ExQ1	Question to:	Question:
2.	Air Quality and Emissions	
2.0.5	NCC, BC, BDC, SNC	ES Chapter 5: Air Quality [APP-044] paragraph 5.4.10, are the parties happy with the approach taken with regards to PM2.5? If not, please explain.
	NCC Response:	District colleagues should be contacted/involved so as able to add more detail about PM10 and PM2.5 calculations as these may feature in their ASR returns. Please note PM2.5 limits may be impacted by the Environment Bill so current non-exceedance may potentially change in the future. Whilst these levels may not be known for certain it may be that WHO levels become a longer-term aspiration.

Norfolk County Council

Identification No: TR010038

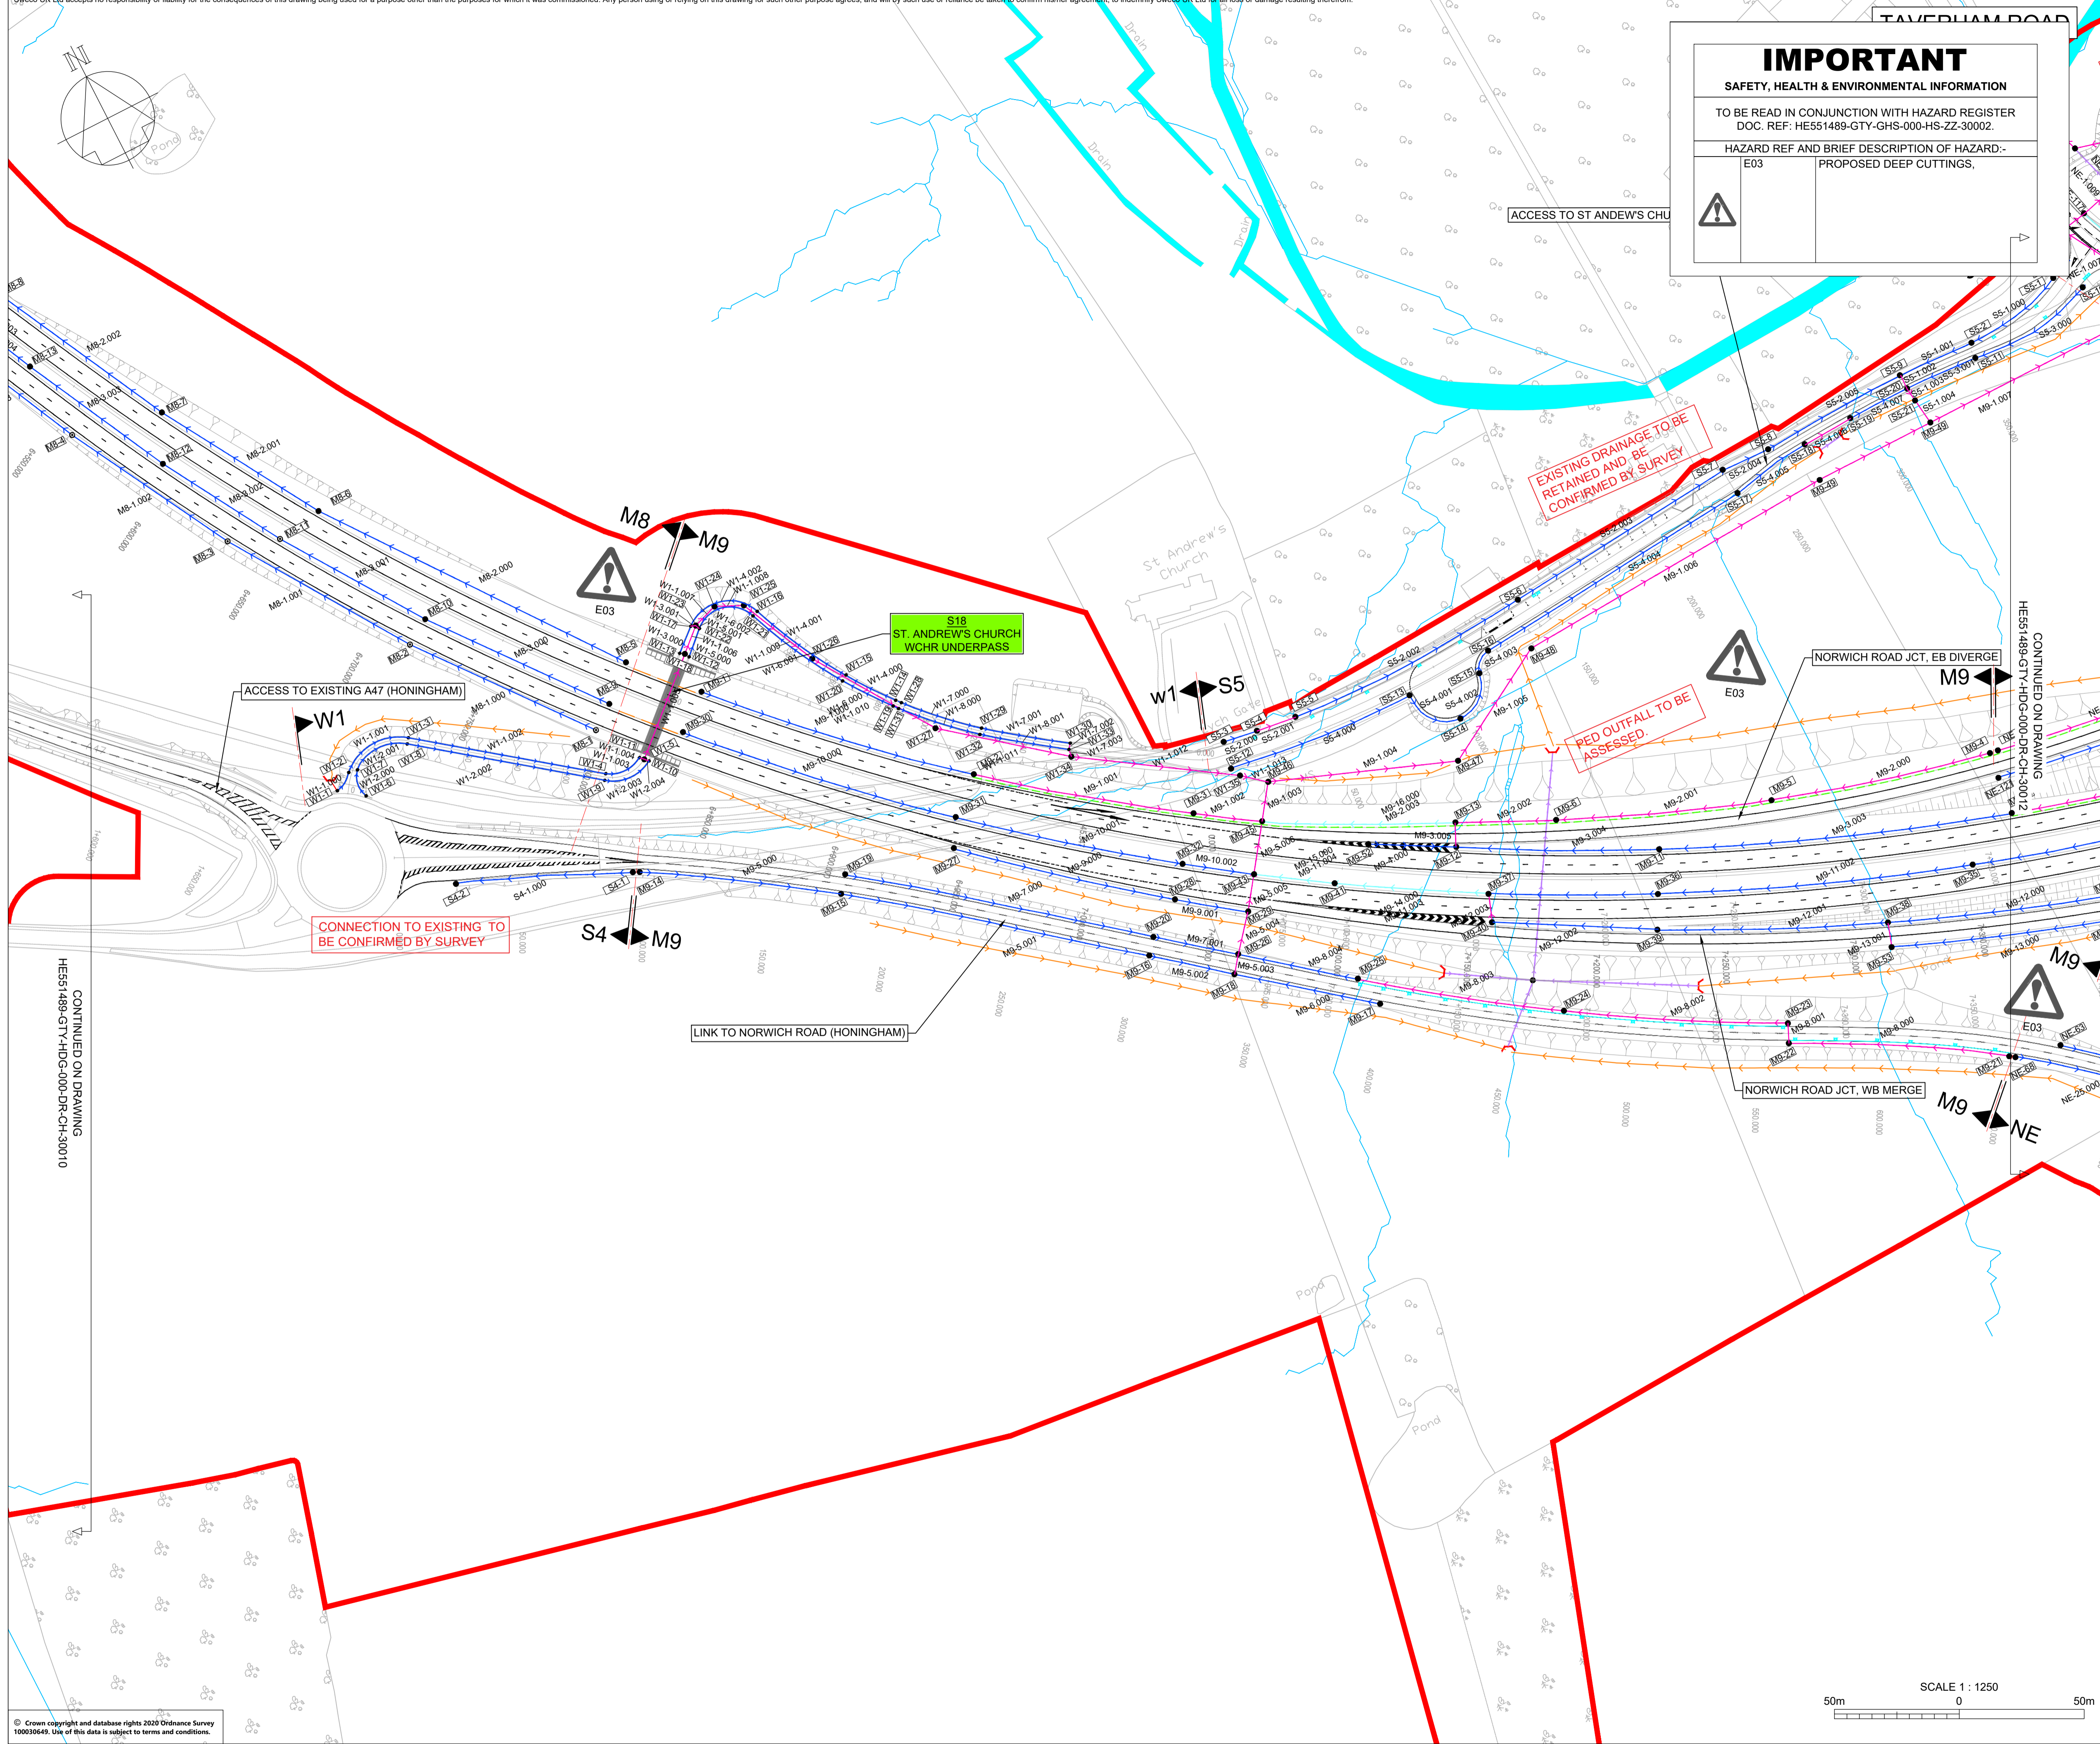
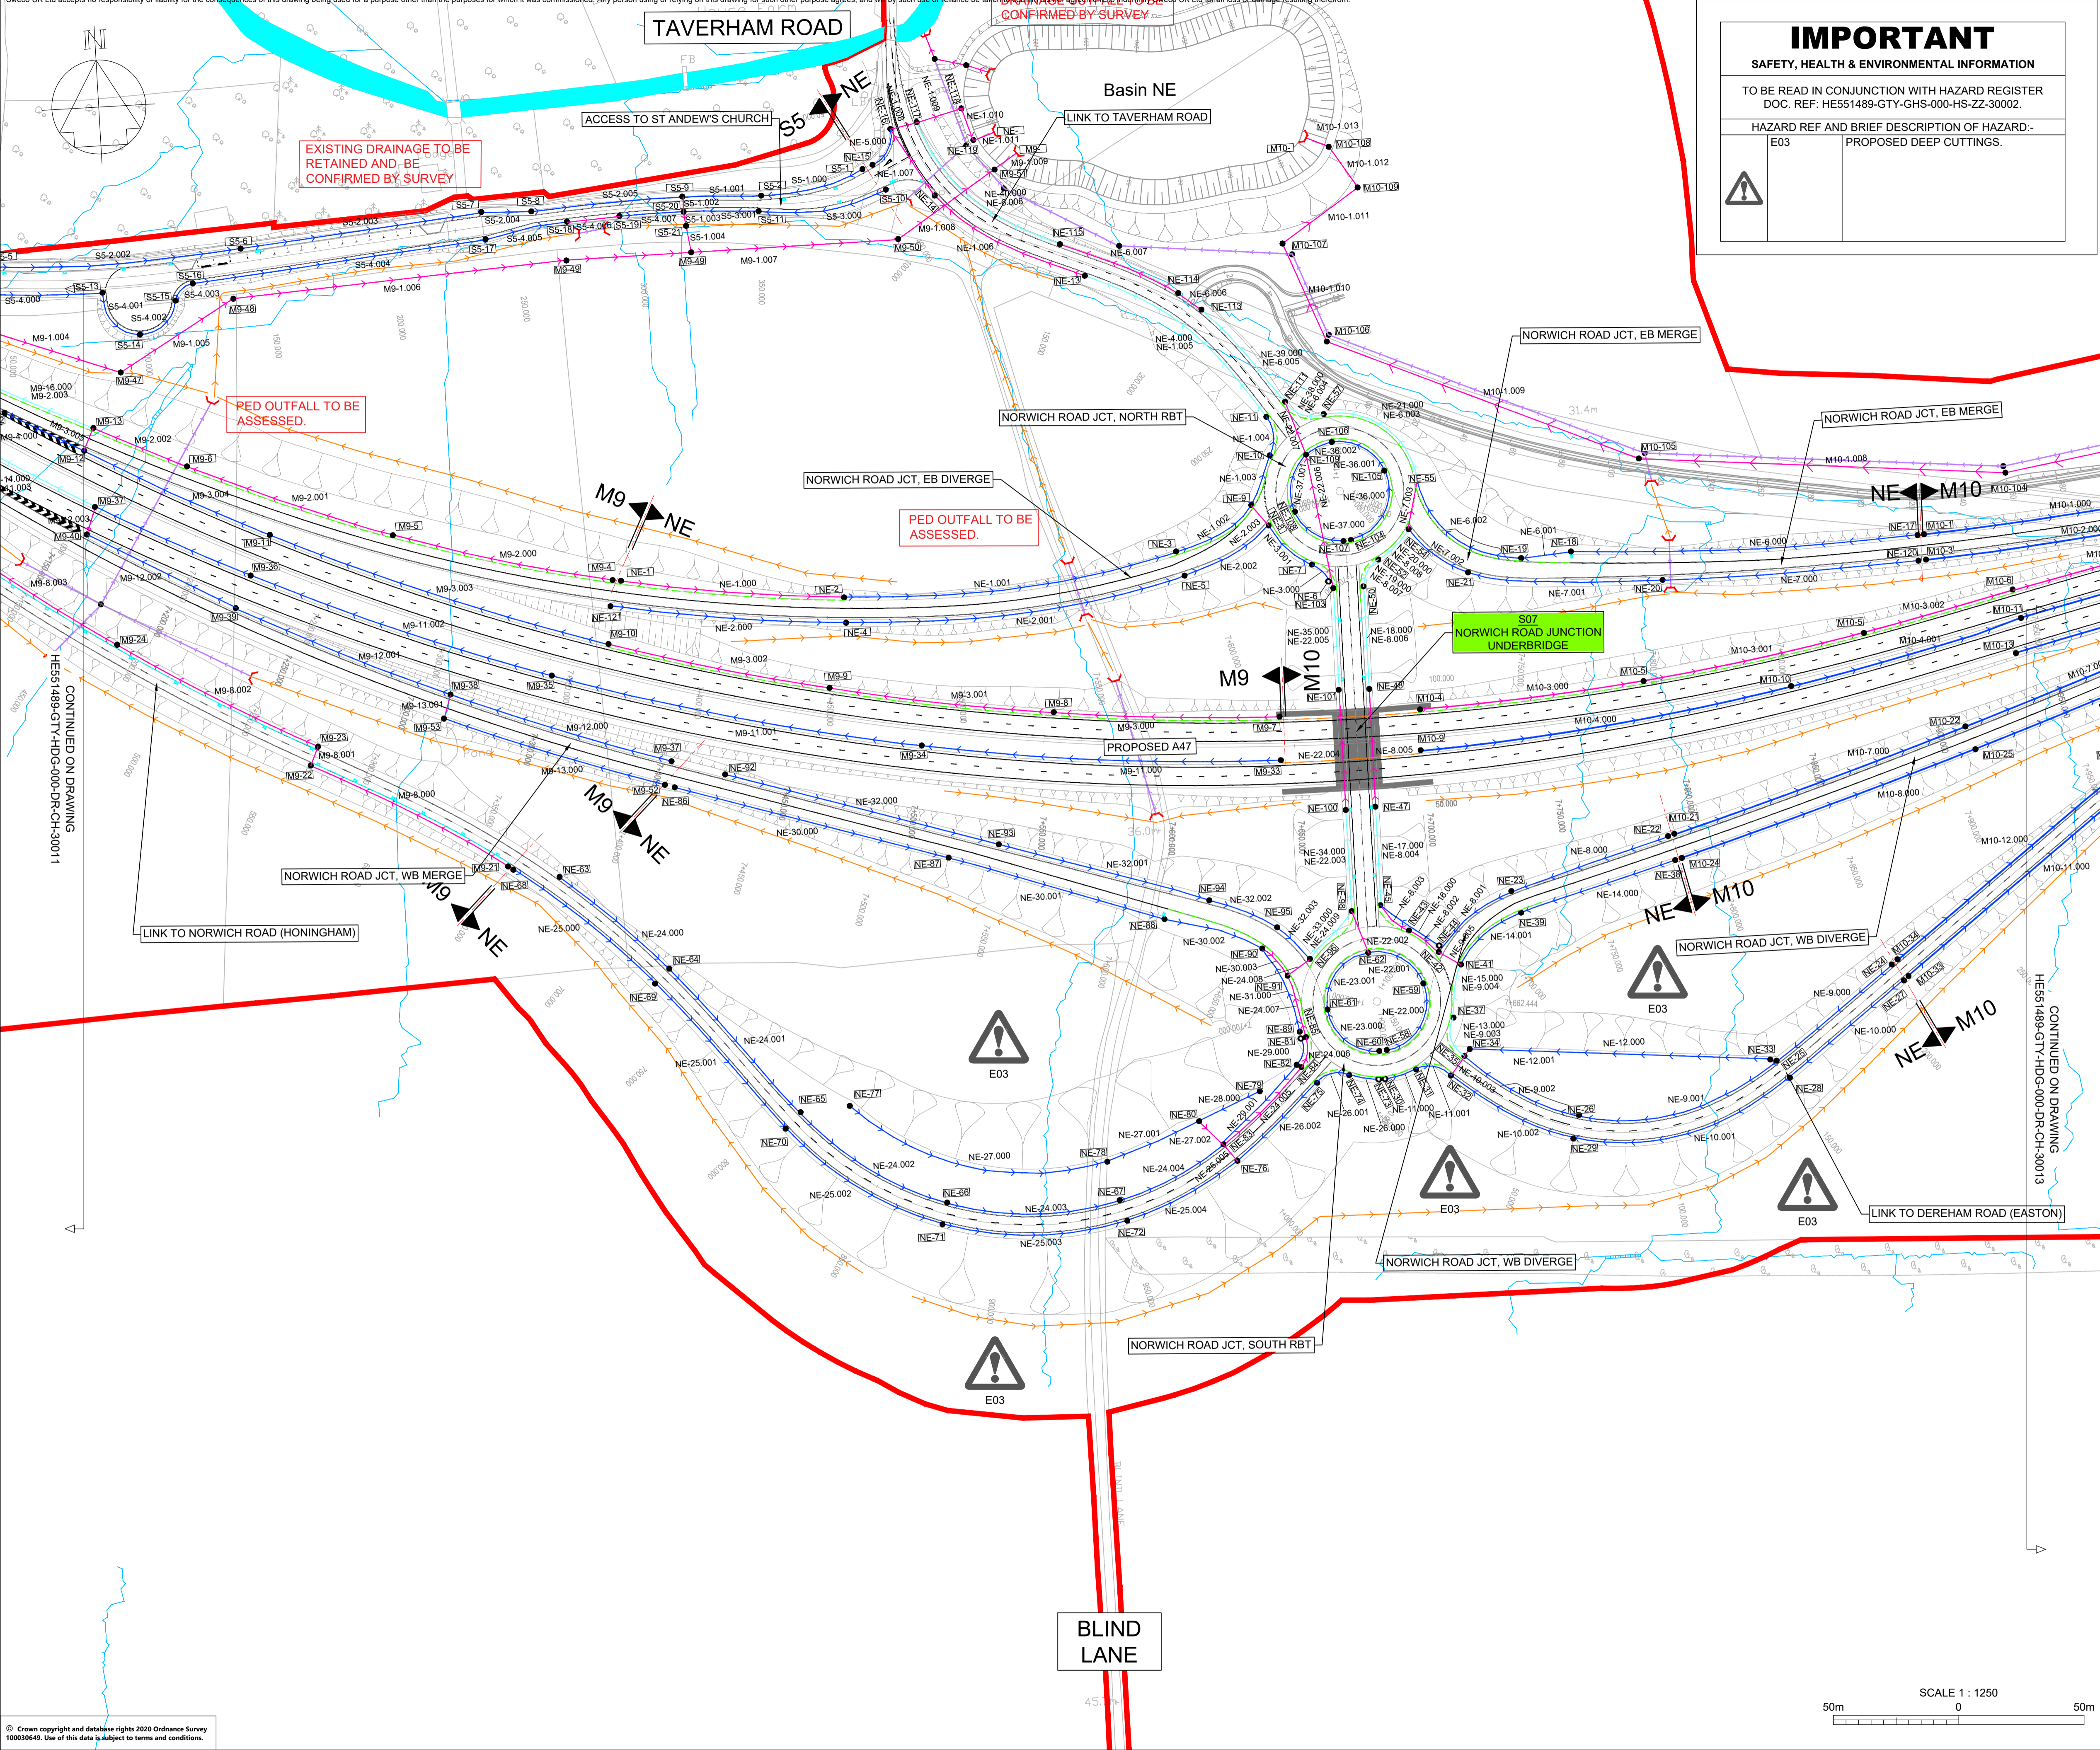
15.0.13	EA, NE, NCC, BC, BDC, SNC	ES Chapter 13: Road drainage and the water environment [APP-052], paragraph 13.9.22 refers to the Drainage strategy (Appendix 13.2 (TR010038/APP/6.3)) which proposes all road drainage will drain by surface water outfalls to the River Tud and its tributaries at twelve locations, utilising nine new outfalls. Is this approach acceptable to parties and in their view, is it adequate to deal with surface water and does it make suitable allowances to cover the design life of the Proposed Scheme?
	NCC Response:	<p>The GI results reported in section 4.3 indicate that infiltration to ground is poor to very poor in the Lowestoft formation while in the Sheringham Cliff Formation were moderate to good. However, the availability of the Sheringham Cliff Formation is limited along the route and are mostly small isolated areas of the formation that is surrounded by the Lowestoft Formation. Therefore, the opportunity in most areas is limited across the site. Along the existing A47 road there are 9 outfalls that discharge to the local surface water drainage network. The approach of discharging to a watercourse is considered acceptable. Supplementary GI was indicated for the first quarter of 2021, although as yet the LLFA has not had sight of this information.</p> <p>In section 6.6.3 of Appendix 13.2, the LLFA notes that the developer proposes to attenuate flow only in catchments where any increase in flow is found to be excessive. The developer confirms their intention to use either oversized pipes in the verge or ditches. This is considered by the LLFA to be a traditional drainage solution and would not be in accordance with the NPPF principles that seek the inclusion of SuDS on major developments and that there should be no increase in flood risk elsewhere from the development. It has not been possible to compare the pre and post development run off rates as no comparable information has been provided. The LLFA had previously raised the lack of clarity on this matter prior to DCO submission but there has not been addressed as yet.</p> <p>The scheme's drainage design has relied heavily on the guidance that is provided in the DMRB, yet there is only limited consideration of the LLFA guidance on the inclusion of SuDS that is derived from National Policy. The LLFA observes that of the 18 surface water drainage networks only 13 of the networks include SuDS features. This means that 5 of the networks are not including SuDS. The use of attenuation basins is the limited way that SuDS have been included within the scheme. Based on the report, the attenuation basins are used to address only one of the four pillars of SuDS; water quantity. The rest of the proposed drainage scheme relies on traditional road drainage structures that do not provide value in terms of water quality,</p>

amenity or biodiversity. This is at an odd position to the scheme's proposals to seek to replace the ponds and the associated habitat that would be lost but has missed an opportunity to better incorporate SuDS within the proposed scheme. The LLFA is yet to see the supporting pre and post development calculations. Therefore at this stage, the LLFA are not in a position to determine whether there is adequate capacity within the proposed drainage systems.
